**KIRKLEES METROPOLITAN COUNCIL
INVESTMENT & REGENERATION SERVICE**

**DELEGATED DECISION FOR APPLICATION FOR CERTIFICATE OF LAWFUL
DEVELOPMENT**

Reference no.: 2025/CL/90158/E

Description: Certificate of lawfulness for proposed hip to gable
conversion and rear dormer extension

| SIZE: A1 | DRG NO: 24.2779_03 LDC |

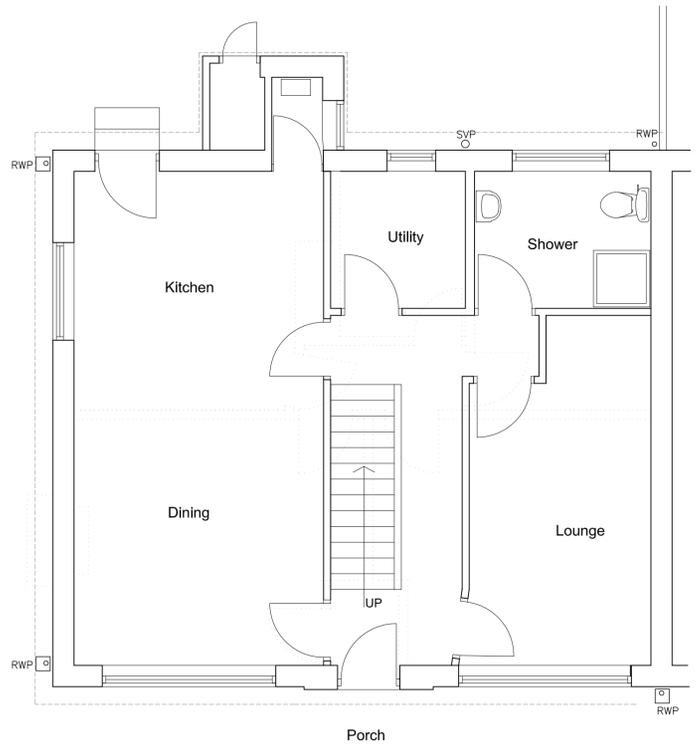
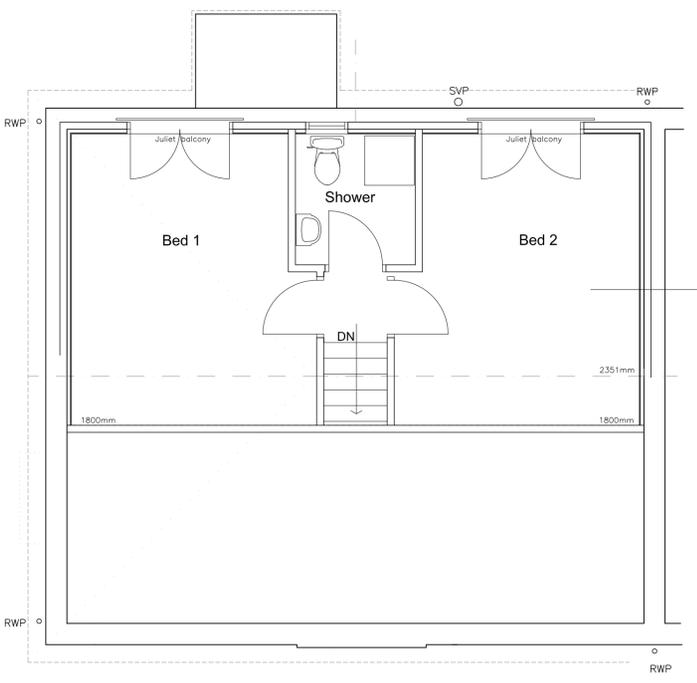
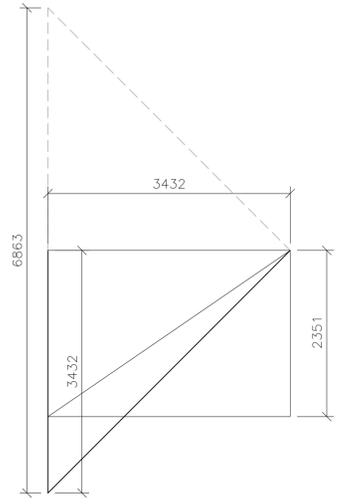
Negotiations were entered into with the agent to reduce the size of the rear dormer. The original submitted plans suggested that the dormer would have a length of 8.3m, depth of 3.5m and height of 2.7m. this would have resulted in the dormer having a 39.2 cubic metre increase, bringing the total submission over 50 cubic metres. It was therefore suggested that the length of the dormer was reduced to 7m to bring it in line with permitted development tolerances.

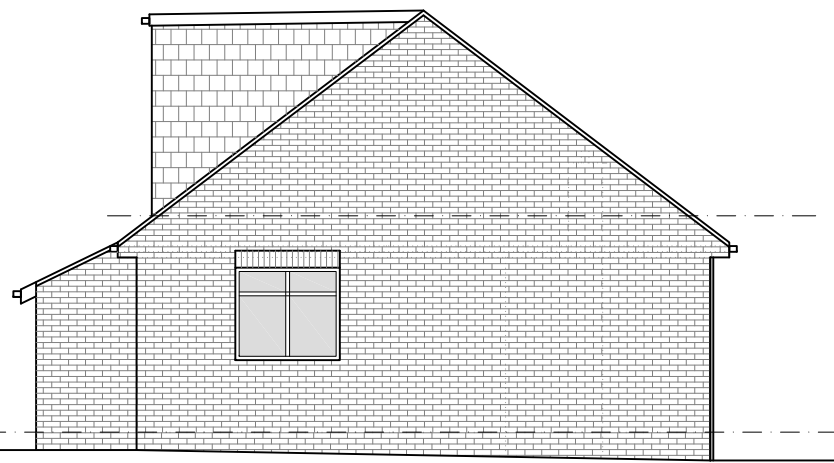
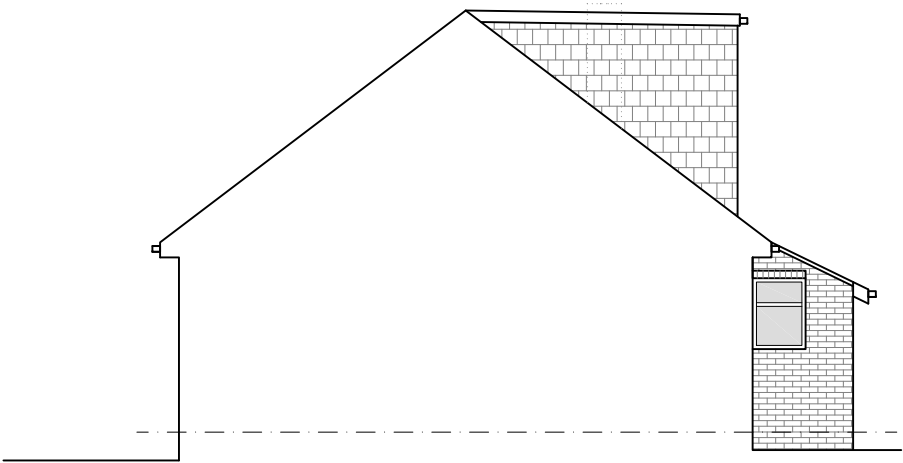
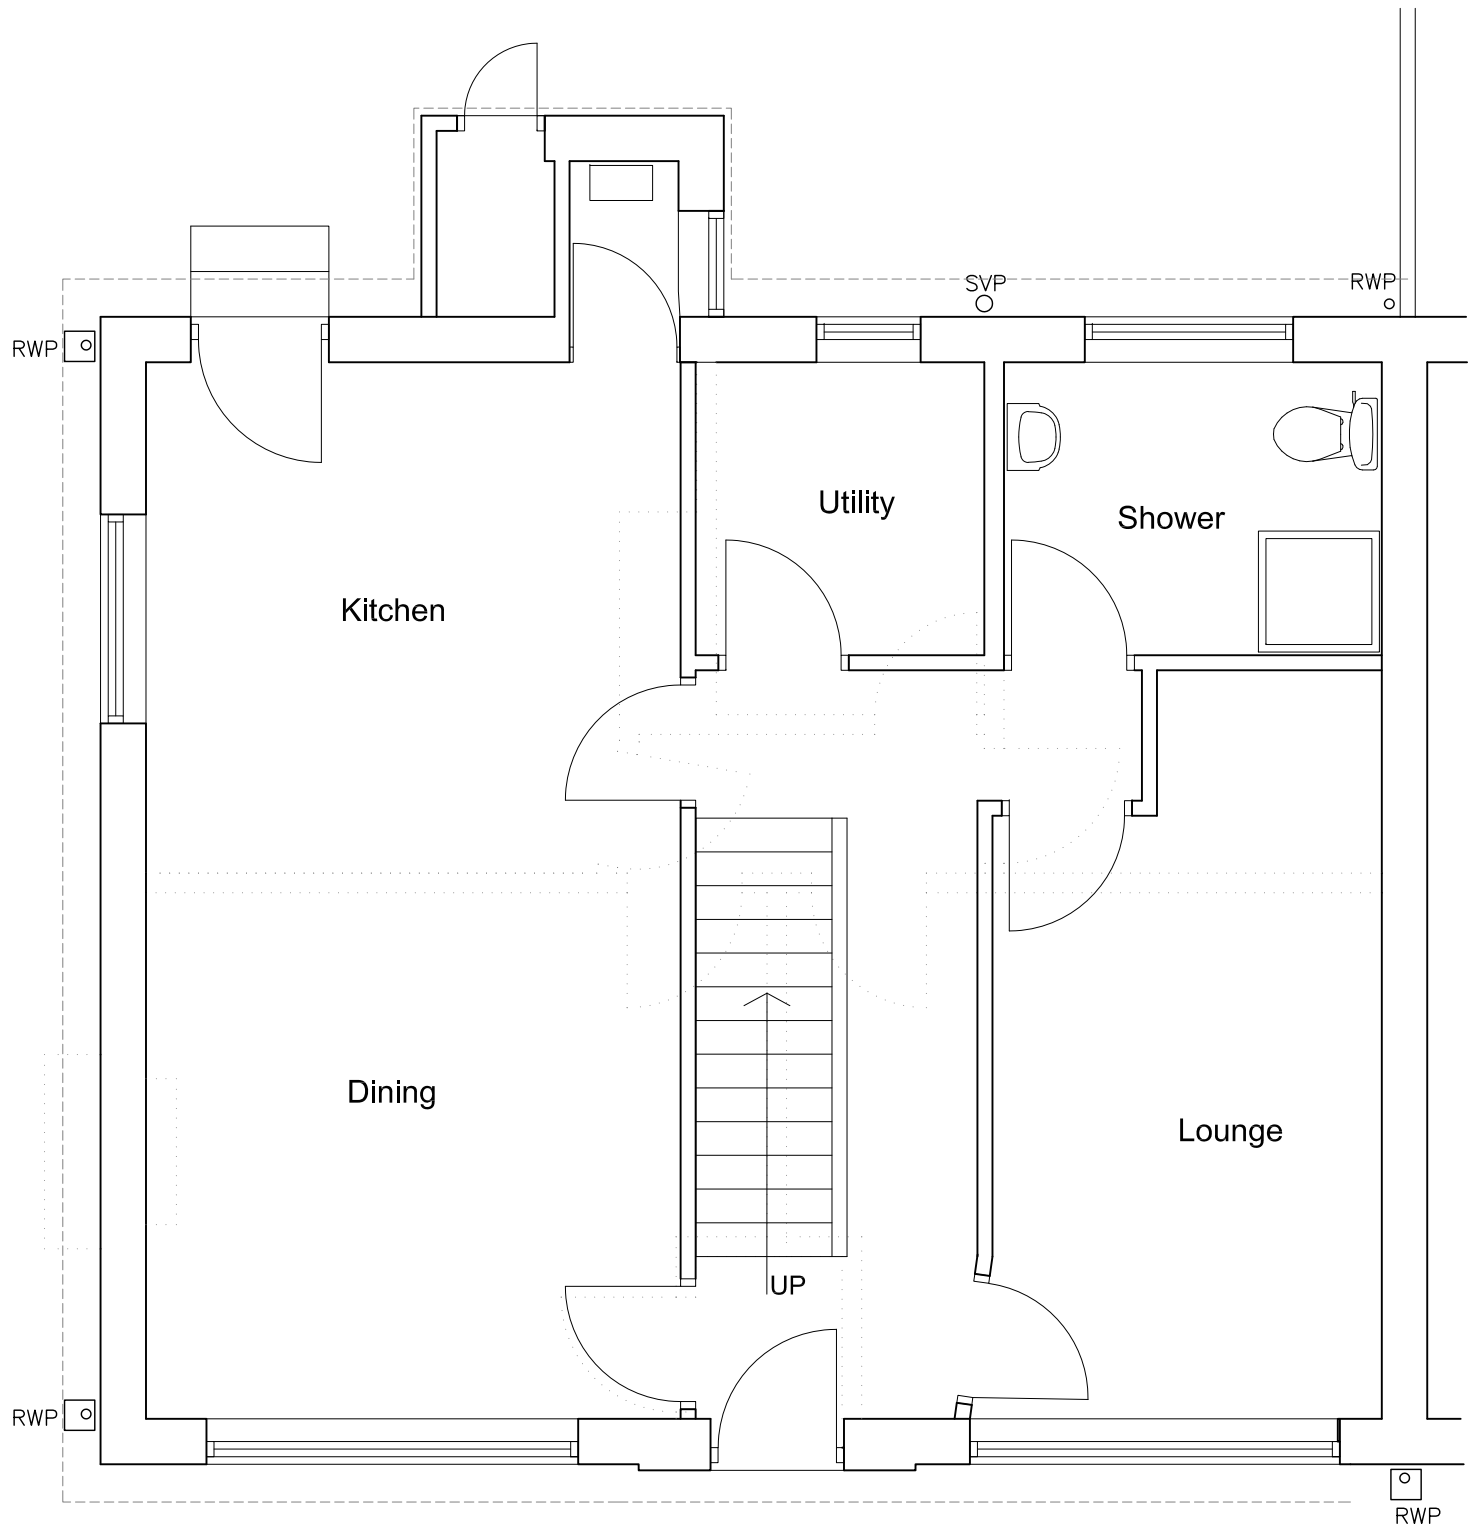
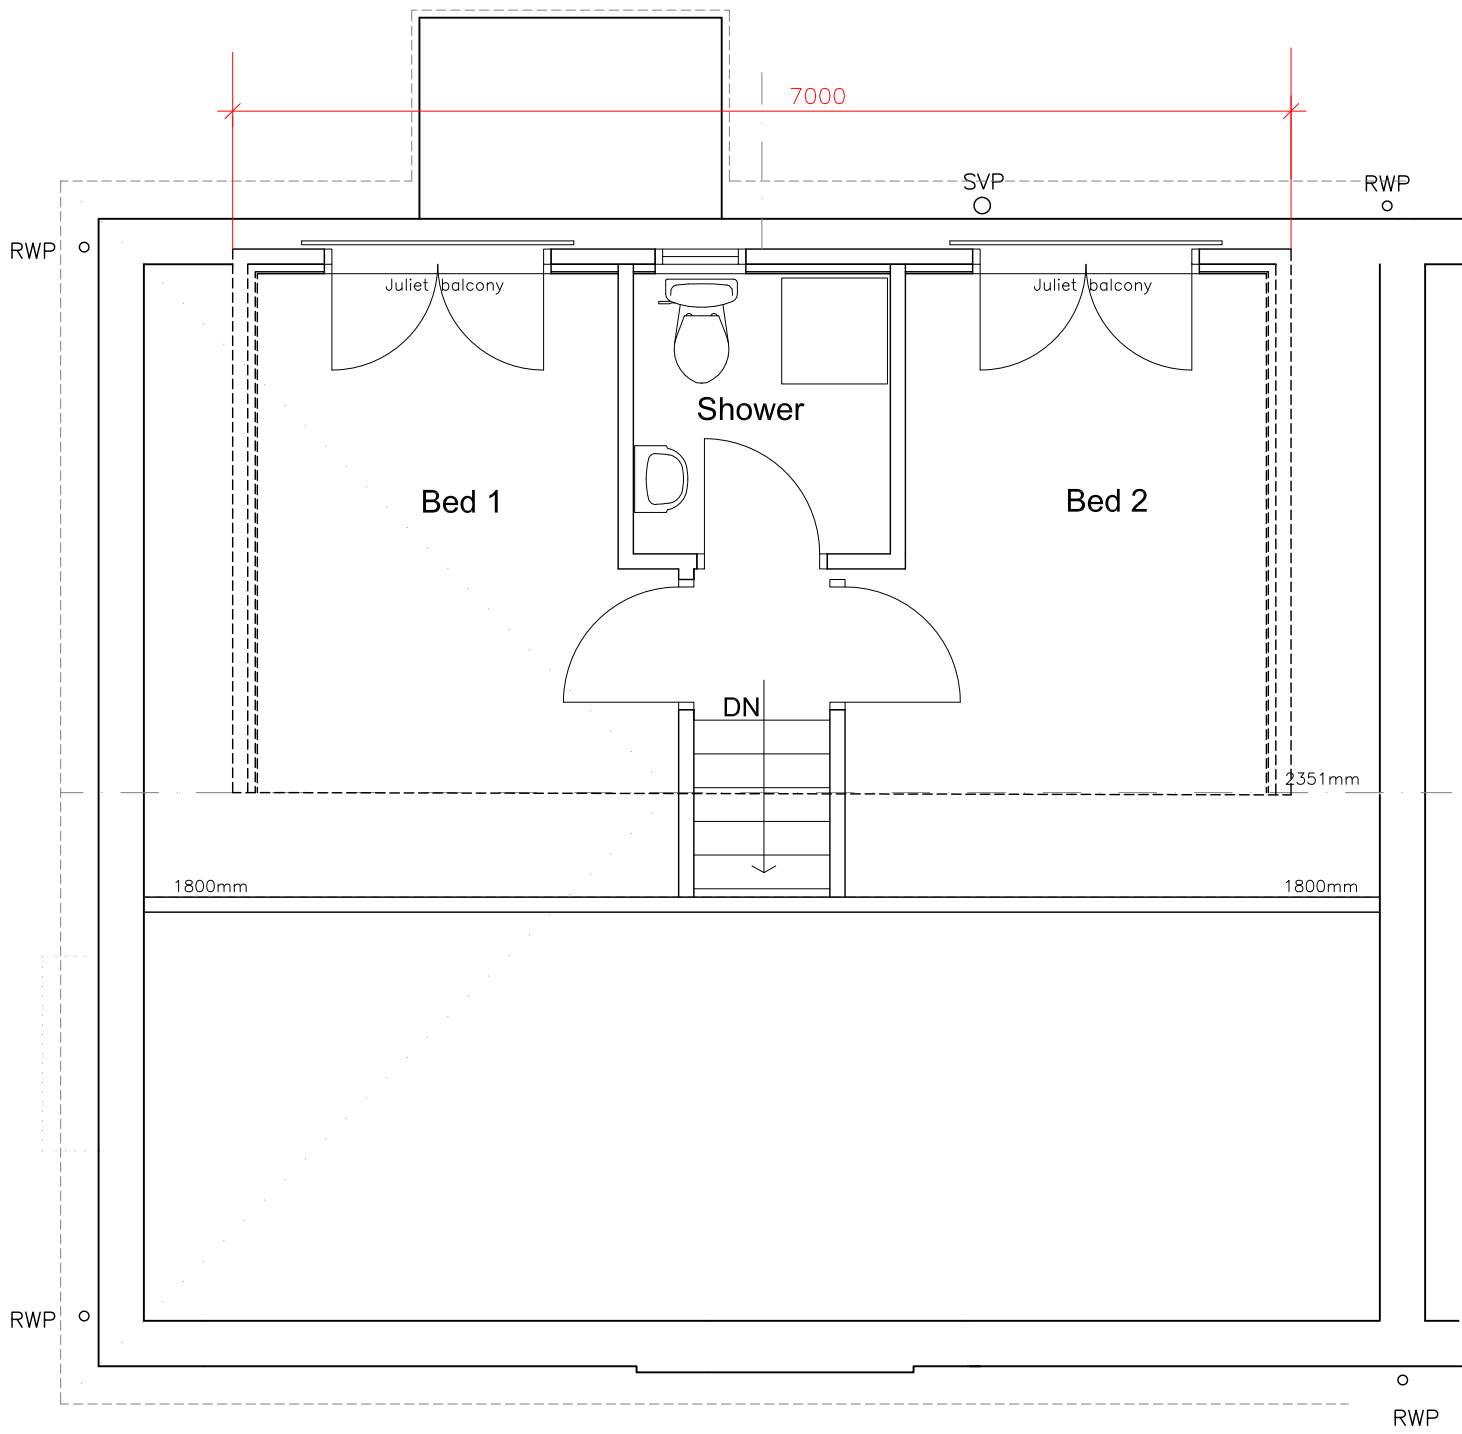
Rear dormer

$$7\text{m} * 3.5\text{m} * 2.7\text{m}/2 = 33.07\text{m}^3$$

Hip to gable

$$8\text{m} * 3\text{m} * 3.7\text{m}/6 = 14.80\text{m}^3$$

Total resultant roof space at 47.87 cubic meters which is under 50 cubic metres.
